REQUEST FOR ADDITIONAL INFORMATION (RFI)
Issued by Department of Planning, Industry & Environment

RFI issued to: Aspect Environmental Pty Limited
Relevant Application: SSD 10431 (Moorebank Precinct West Stage 3) – under assessment
Date of RFI: 7 September 2020
Due Date for Response: 25 September 2020 (revised to 8 October 2020, per agreement DPIE)

Re: MPW3 Soil and Water Management Plan- SSD 10431

Figure 1: SSD 5066 MOD 2 – Existing MPW Stage 2 operational boundary (left) and proposed amendment to operational boundary (right) (Source: Applicant’s SSD 5066 MOD 2 Modification Report).

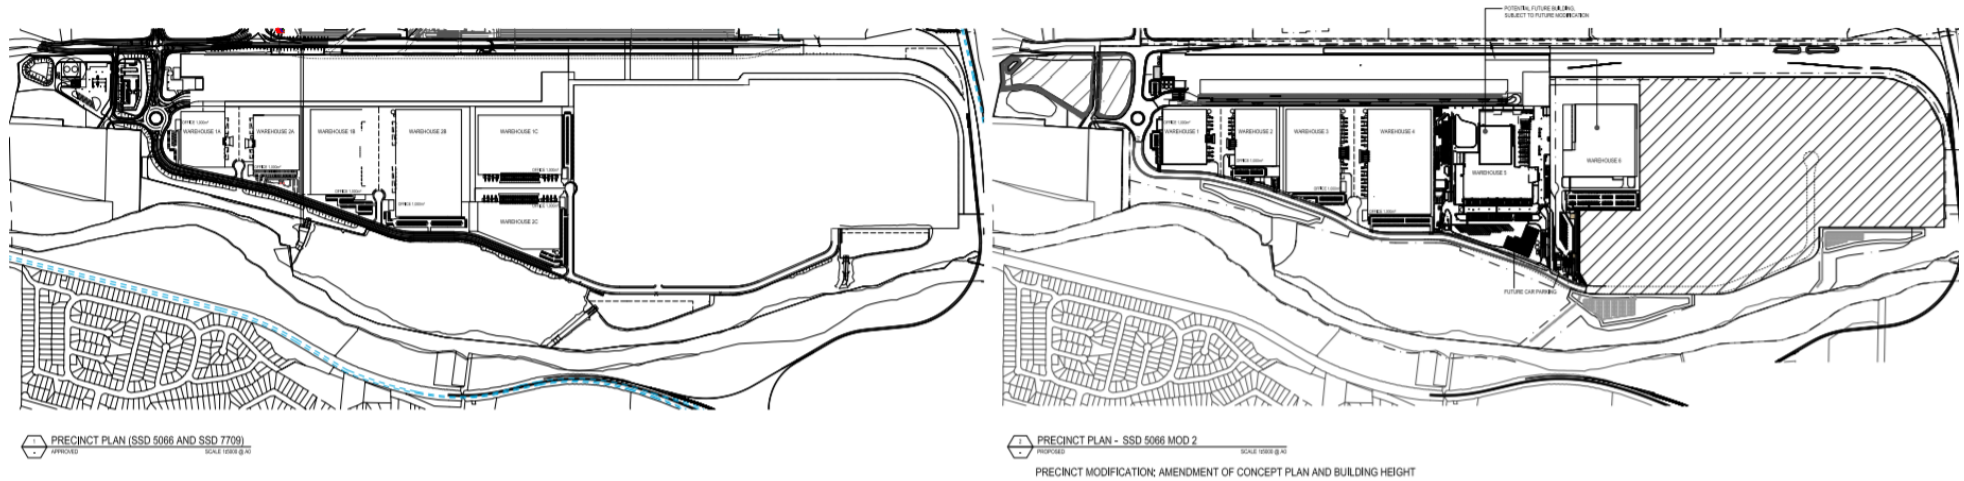
DPIE RFI Matter	Response to RFI Matter
<i>Importation of fill material</i>	Costin Roe has provided a response to the <i>Importation of fill material</i> matter, please refer to attached letter of response.
<i>Subdivision layout of proposed lots 6 and 7</i>	<i>Clarify whether the proposed subdivision configuration of lots 6 and 7 are proposed to be amended to reflect the proposed changes to the existing MPW Stage 2 warehouse configuration and operational boundary, as outlined in proposed SSD 50660 MOD2 and SSD 7709 MOD1.</i>
	The MPW S3 SSD 10431 application was submitted to DPIE in advance of the modification application (SSD 50660 MOD2 and SSD 7709 MOD1) for building height and MPW Stage 2 operational boundary adjustment and is able to be implemented irrespective of the modification. Neither the SSD 10431 or the modification applications propose future use including hardstand or infrastructure within the areas of proposed Lots 6 and 7 which are located outside of the adjusted MPW Stage 2 operational boundary (other than use for access, services and/or utilities).

DPIE RFI Matter	Response to RFI Matter
	<p>Section 4.1 of MOD 1 (SSD 7709) <i>Modification Application Planning Report</i> (Willow Tree Planning, 2020) for a proposed height increase advised that <i>"the proposed [height] modifications would not alter the quantity of configuration of land currently zoned for industrial-related development on the Subject Site."</i> The proposed modification (SSD 7709 MOD 1) to provide high density warehouse storage as required by the tenant and therefore maximise the overall capacity of the lot will enable the remaining lot areas outside of the MPW Stage 2 operational boundary to be utilised for additional industrial-related development, consistent with the intent and nature of the site.</p> <p>Areas on proposed Lots 6 and 7 outside of the adjusted MPW Stage 2 operational boundary and to the west of the warehouse footprint are of sufficient space to be utilised for additional warehousing or ancillary warehousing facilities such as car parking, offices, hardstand, storage areas, or other uses, subject to future application(s). Further, these areas may facilitate provision of adequate setbacks, building separation, deep-soil landscaping, or screening of the Precinct to sensitive receivers.</p> <p>Site landscaping and road infrastructure will be configured to enable fluid access and continuity for pedestrian and vehicular movements both within and outside of MPW Stage 2 operational boundaries.</p> <p>Environmental assessments for MPW Stage 2 generally considered potential impacts within the MPW Site boundaries, and so no further impacts in relation to the more conservative MPW Stage 2 operational boundaries are anticipated.</p> <p>The operational boundary identified within the modification documentation does not represent a subdivision boundary, nor is the operational boundary inconsistent with the proposed subdivision boundary. Partial coverage of a lot by warehousing aligns with MPE, where multiple tenants and common areas are located on a single lot. The proposed subdivision of the site will not compromise the efficient operational use of the land and the functionality of proposed warehouse and distribution facilities. All the property rights proposed as part of the proposed subdivision remain relevant.</p>
